# GRADING & EROSION CONTROL PLANS

## TRIVIEW METROPOLITAN DISTRICT NORTHERN DELIVERY SYSTEM BOOSTER PUMP STATION

### EL PASO COUNTY NOVEMBER 2022

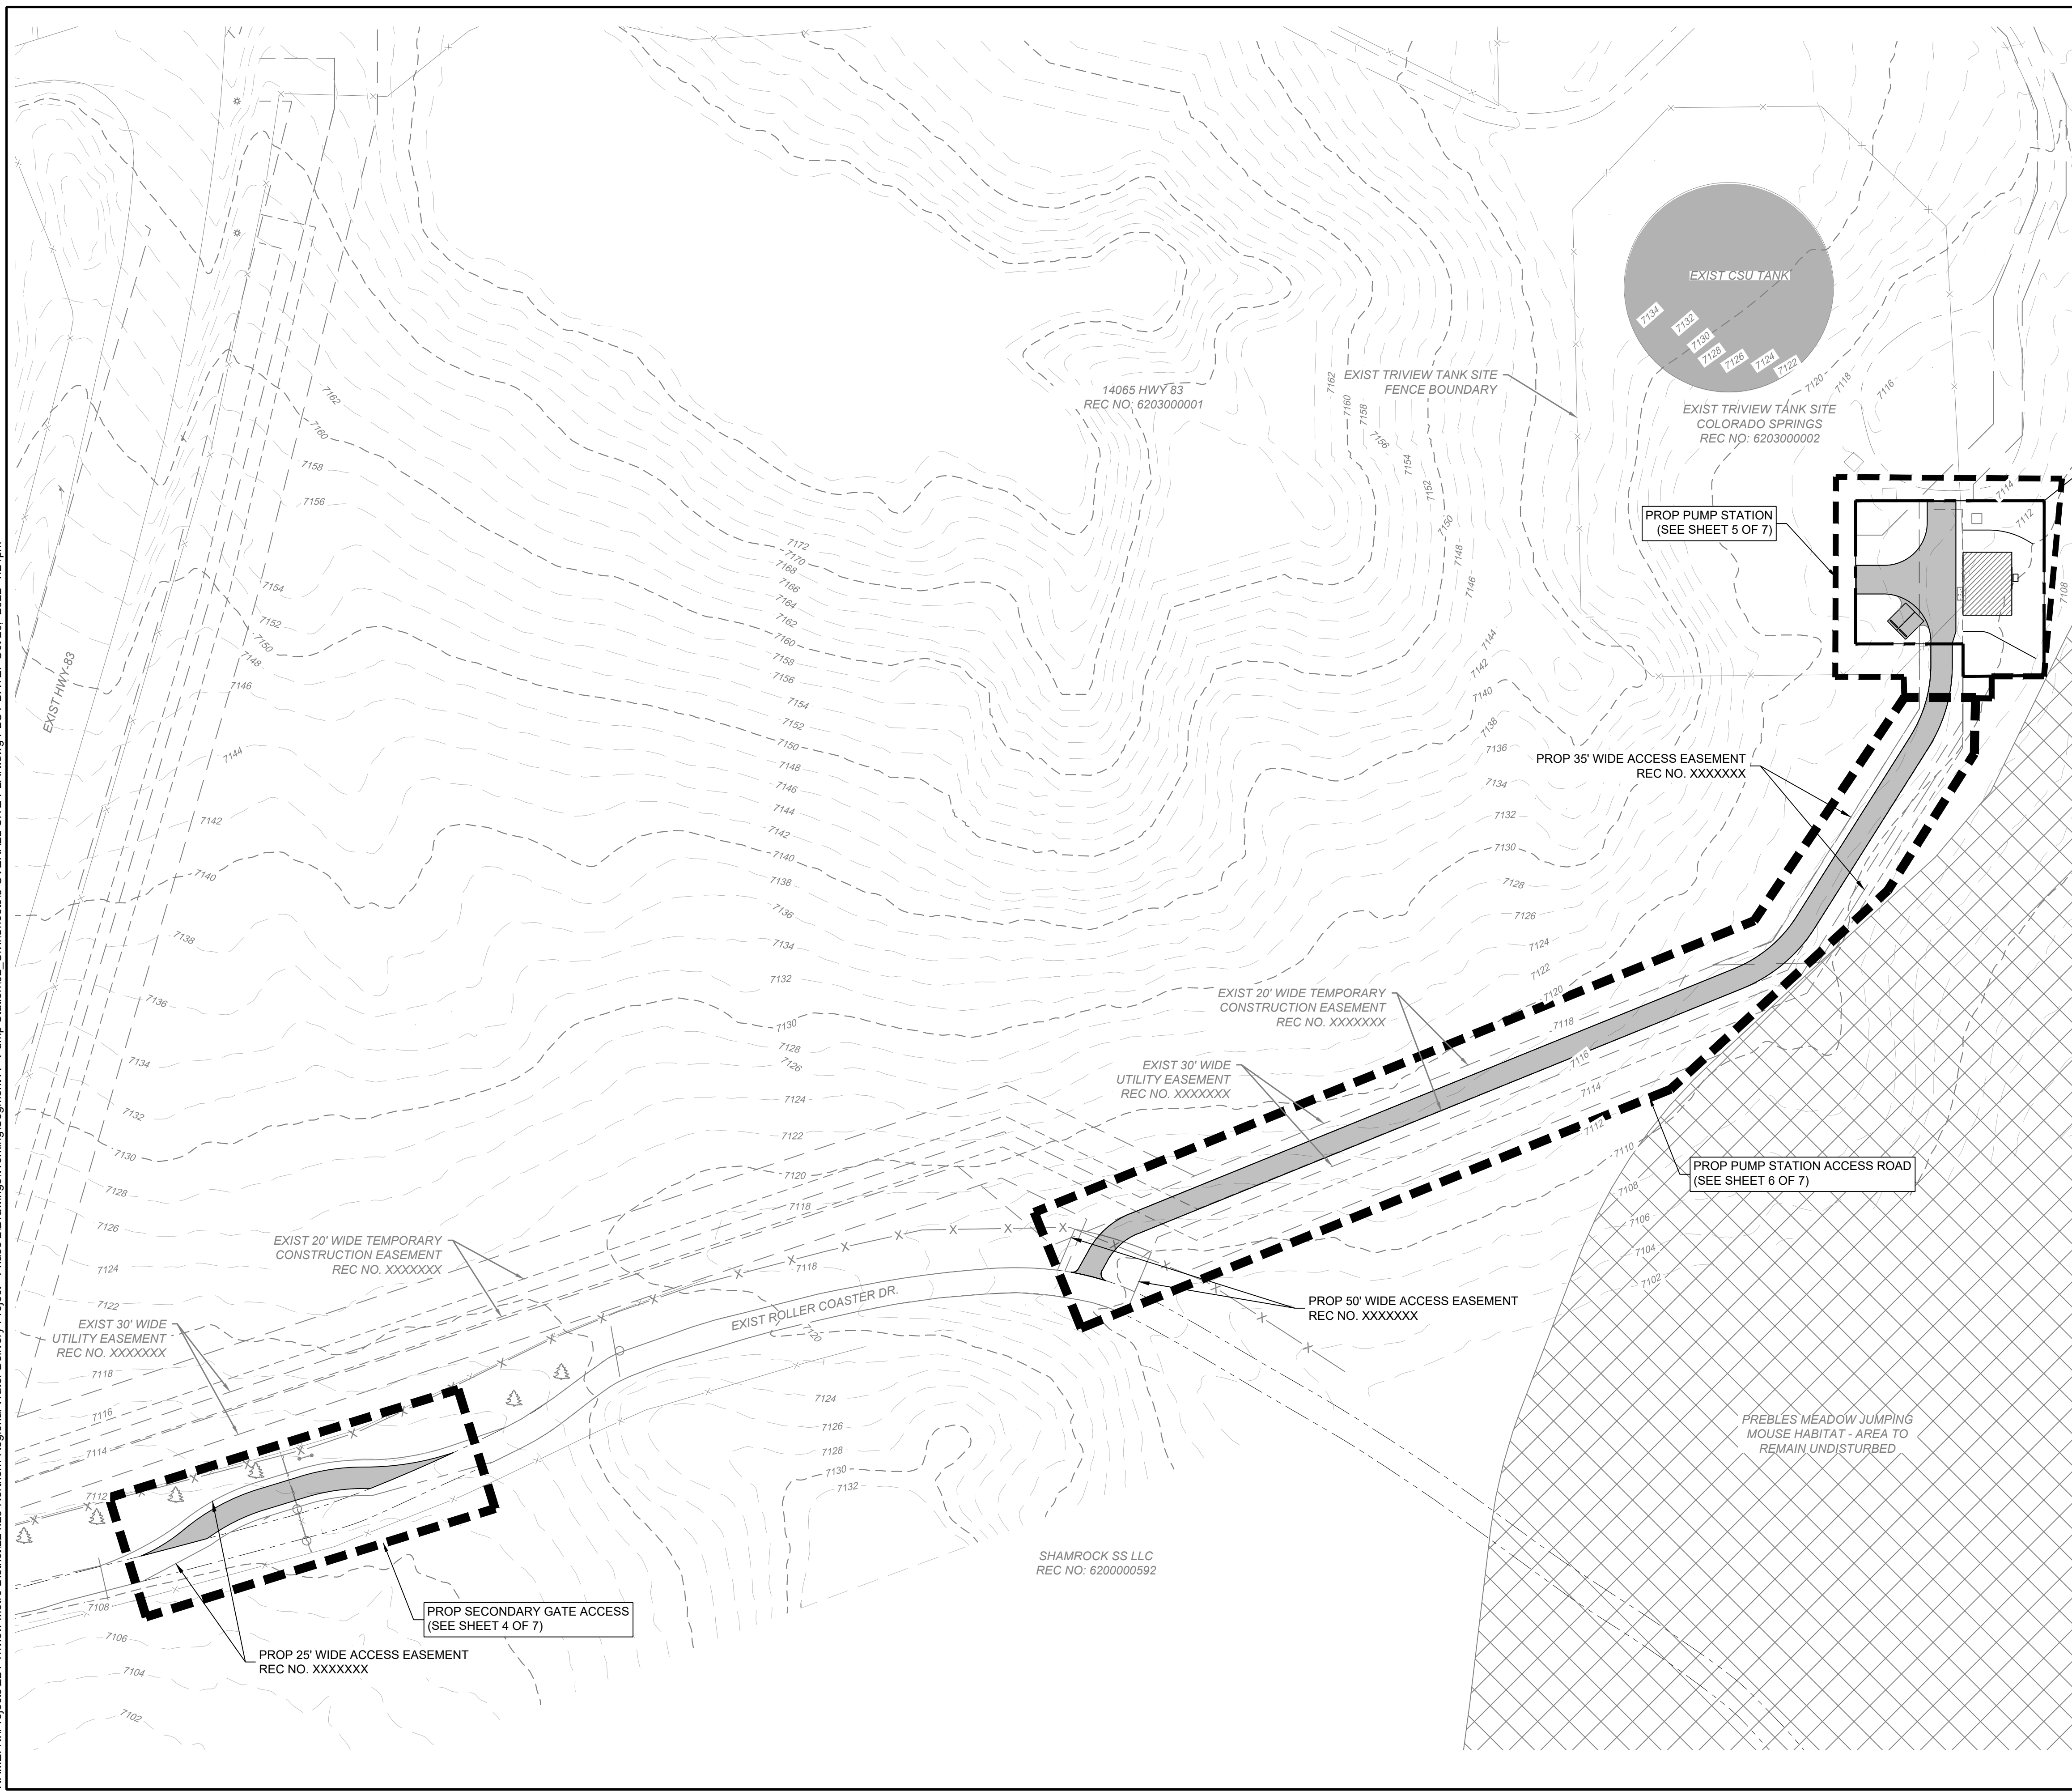
Add:
23. No person shall cause the impediment of stormwater flow in the curb and gutter or ditch except with approved sediment control measures.

is there a downstream sediment basin for this project?
